Recommendation Report for Works to Tree(s) on trees subject to a Tree Preservation Order (TPO)

REF NO: FP/182/21/T

LOCATION: 11A Outerwyke Avenue
Felpham
PO22 8JH

PROPOSAL: 1 No. Turkey Oak - reduce limbs by 3m to leave 5m.

REF 1

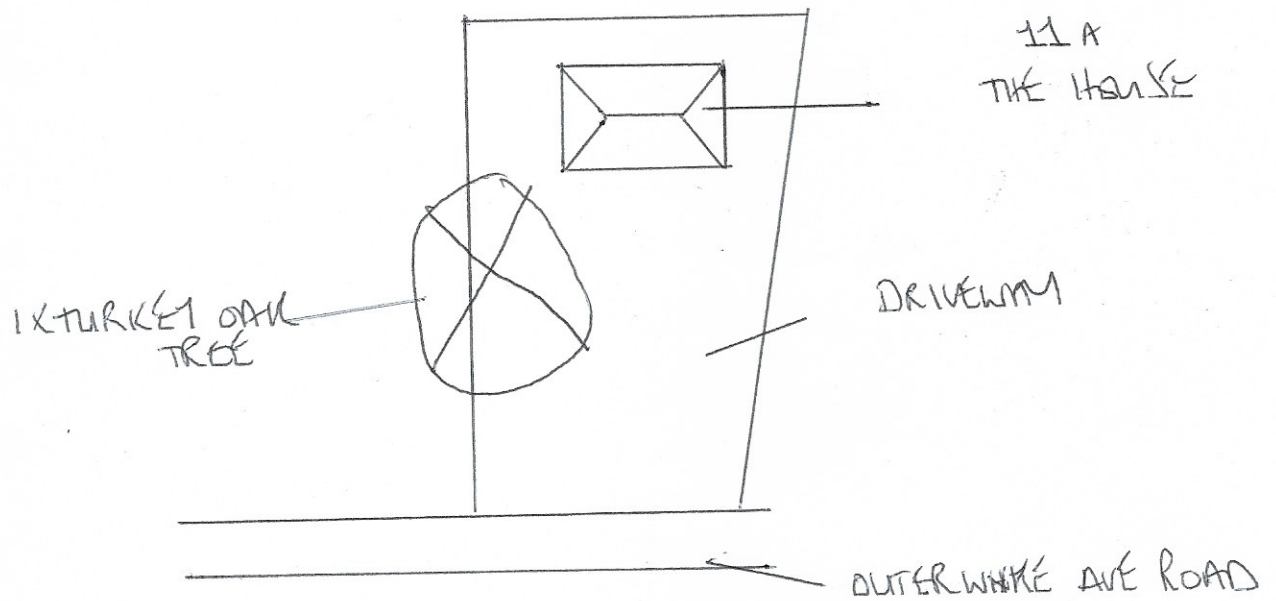
The extent of crown reduction being sought is approximately -60% of crown volume. In the absence of any overriding and proven safety issue or damage event, such a drastic operation fails to meet the requirements of British Standard 3998:2010 Tree Work - Recommendations.

The proposal to reduce both height and lateral spread on all aspects by 3m respectively does not comply with 'British Standard (BS3998:2010) Tree work - Recommendations' and would be likely to result in harm to the health and vitality of the tree with large pruning wounds being formed as well as undermining its visual amenity value and impact in the landscape.

- 1 This application has been refused due to the proposal to reduce both height and lateral spread on all aspects by 3m respectively does not comply with 'British Standard (BS3998:2010) Tree work - Recommendations' and would be likely to result in harm to the health and vitality of the tree with large pruning wounds being formed as well as undermining its visual amenity value and impact in the landscape.
